Application Ref:	3/2020/1055	 Ribble Valley Borough Council www.ribblevalley.gov.uk	
Date Inspected:	7/1/2021		
Officer:	BT		
DELEGATED ITEM FILE REPORT:		Decision	Approval

Development Description:	Proposed single storey extension and dormer to rear.
Site Address/Location:	Mayfield, Whalley Road, Simonstone. BB12 7HT.

PROPOSED FLOOR PLANS, ELEVATIONS, SECTION & ROOF PLAN

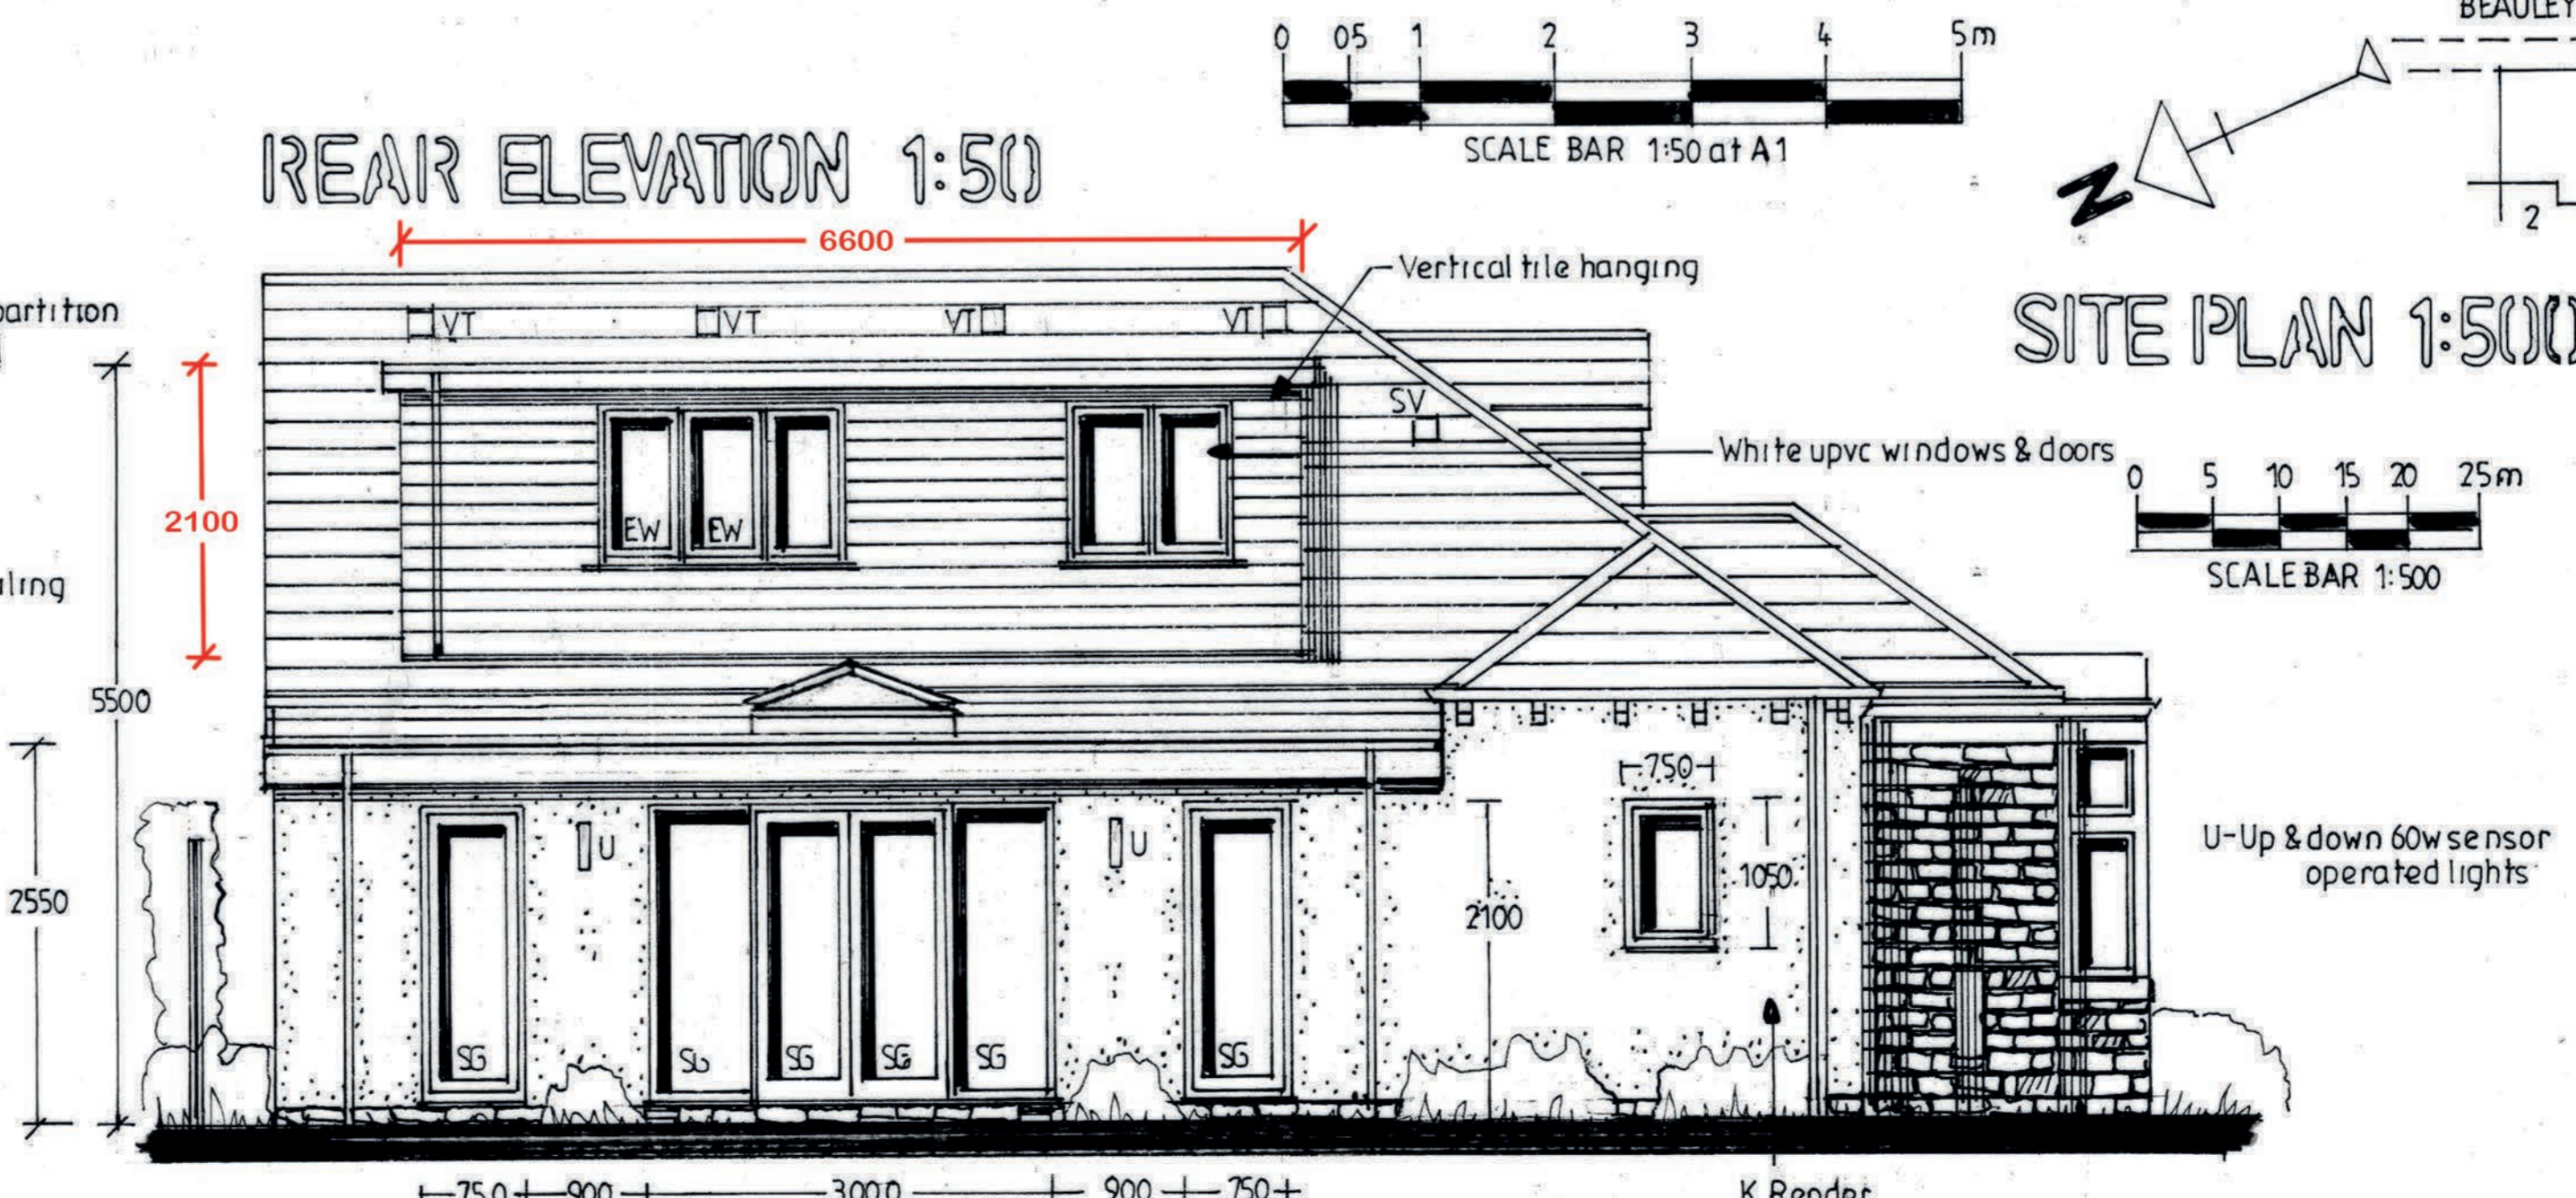
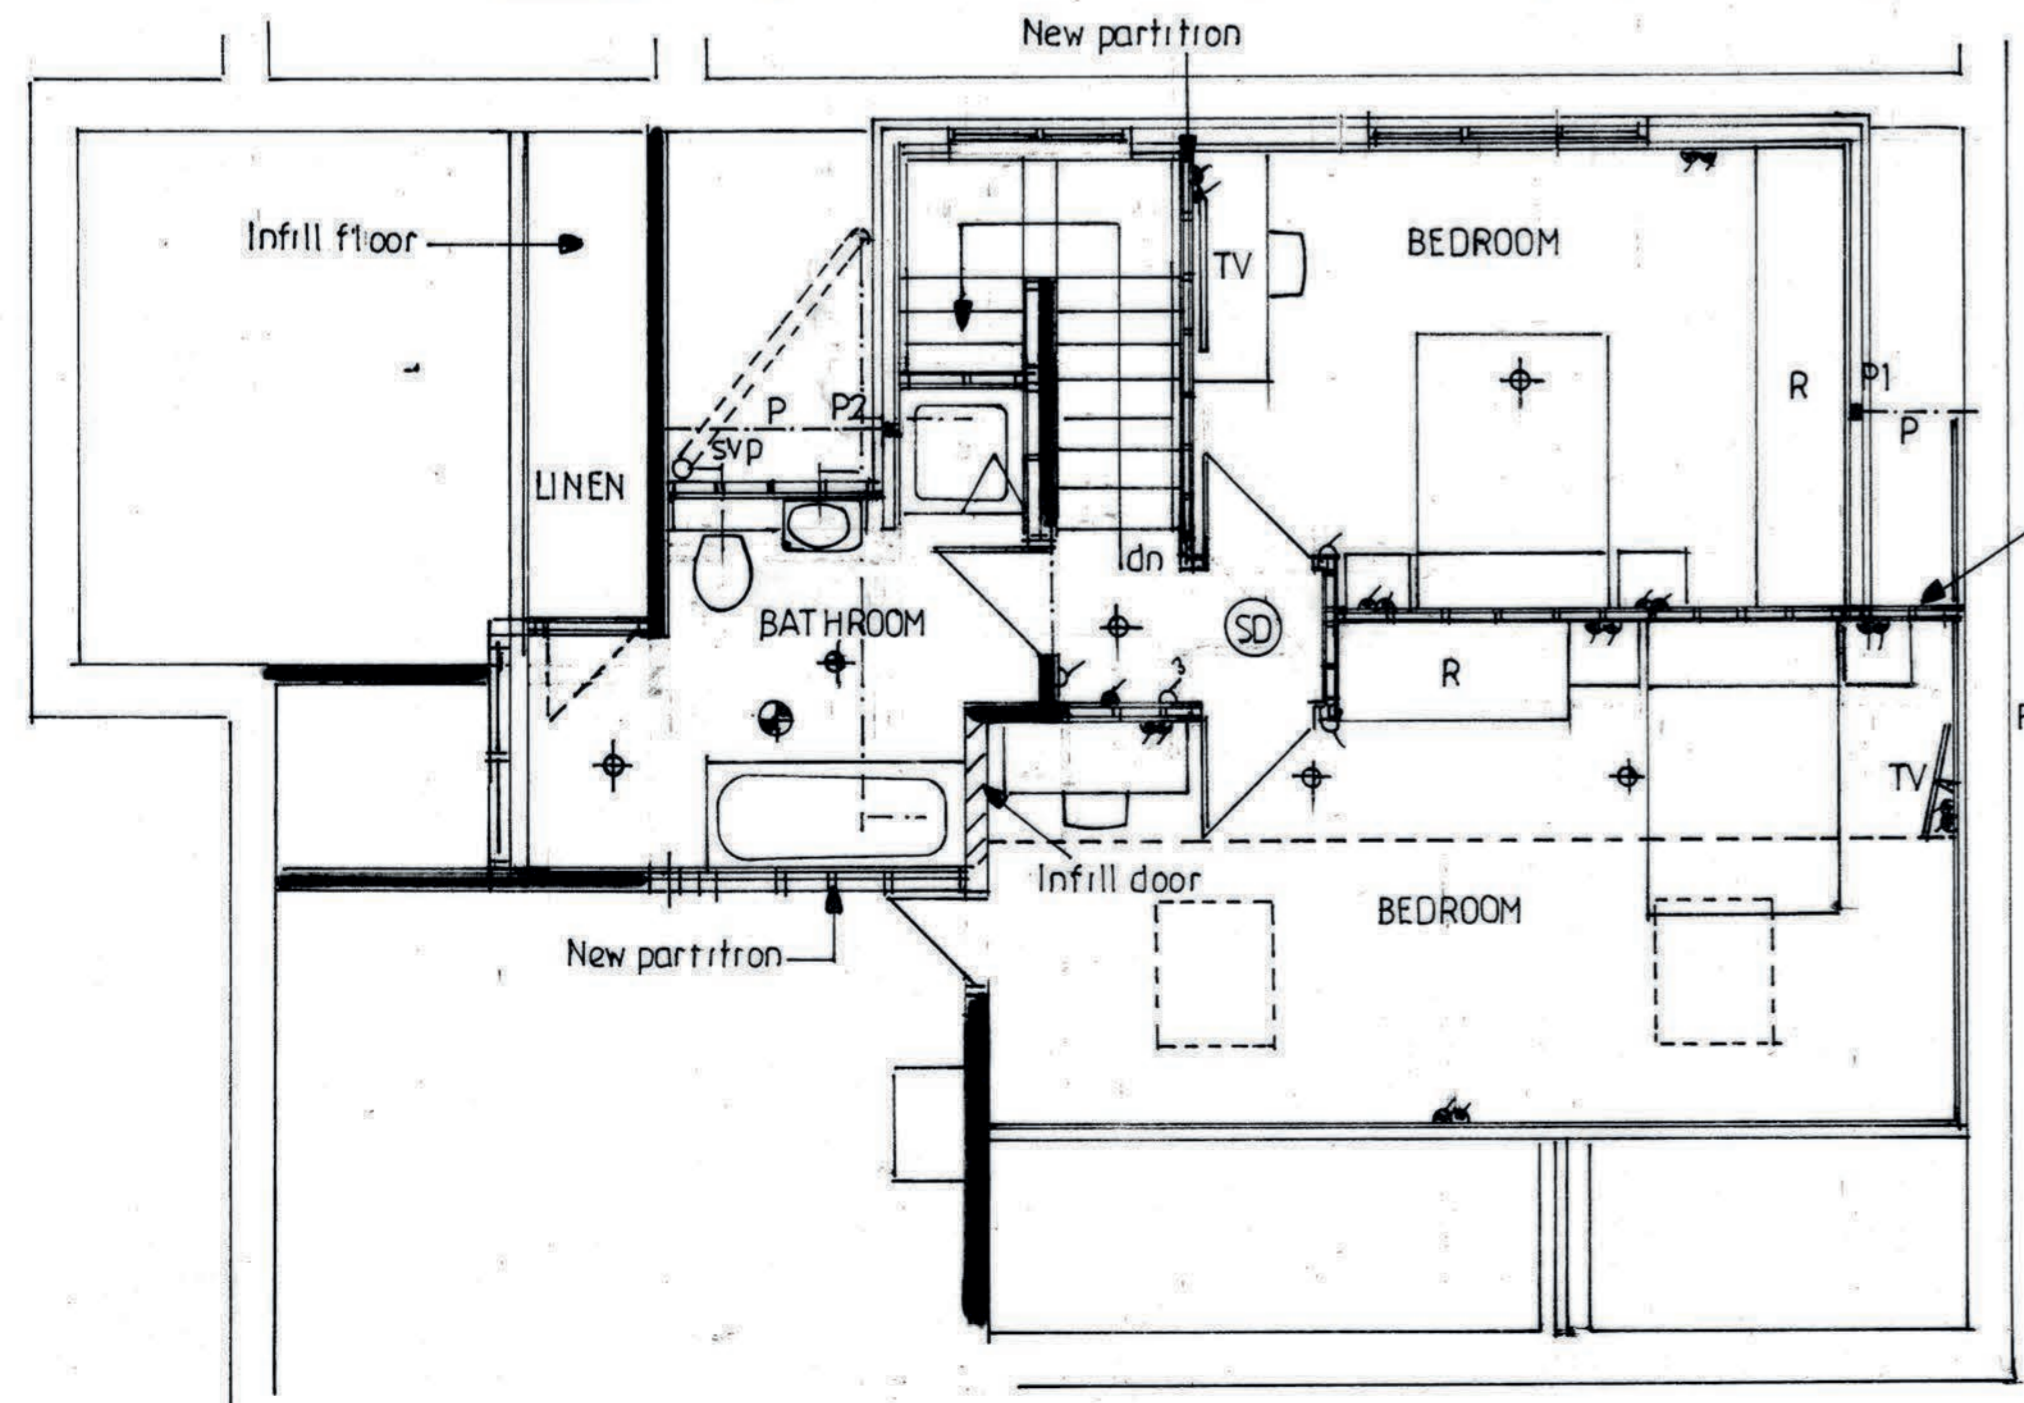
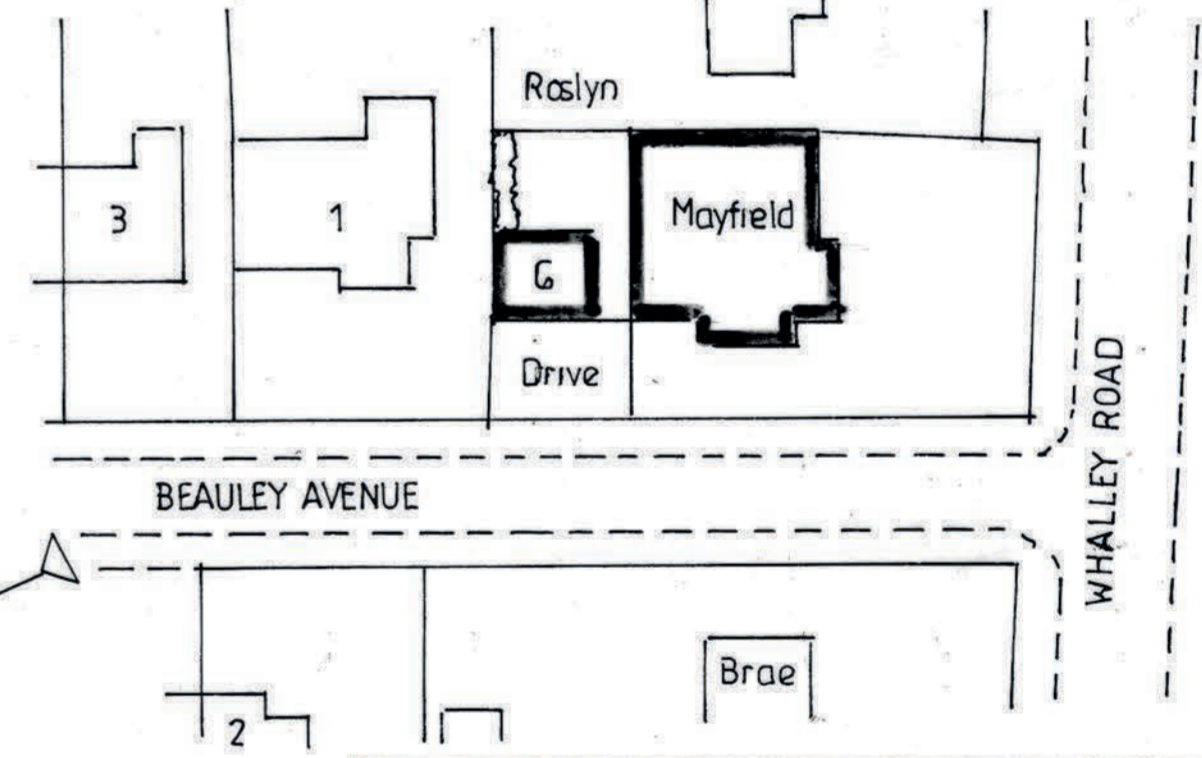
The single storey extension on the proposal's North-east elevation includes numerous windows as part of its design which will allow views into the property's rear garden. These windows will not provide opportunities for overlooking into neighbouring properties in as much that the single-storey extension will be screened at the ground floor level between the property's boundary wall, hedge and fence.

The proposed rear dormer window faces directly towards the lounge window of the rear neighbouring property at a distance of approximately 17 metres. As such, the proposed dormer window will allow a certain amount of overlooking however the distance between these windows is considered as sufficient enough to prevent any serious infringement of privacy.

The proposed dormer window will be situated directly adjacent to the side elevation of the neighbouring property's roof eaves and as such will not have any adverse impact upon natural light or outlook.

The proposed single storey extension will be subservient to the primary dwelling in as much that its eaves and roof pitch height will not exceed those on the main property. Moreover, the extension will be sited largely out of public view at the rear of the property between a boundary wall, hedge and fence therefore its visual impact will be minimal.

The proposed dormer window will measure 2.1 metres in height and 6.6 metres in width and as such will have a relatively conspicuous presence however it is not considered that the proposed dormer window will have an imposing or overbearing presence by virtue of its design.
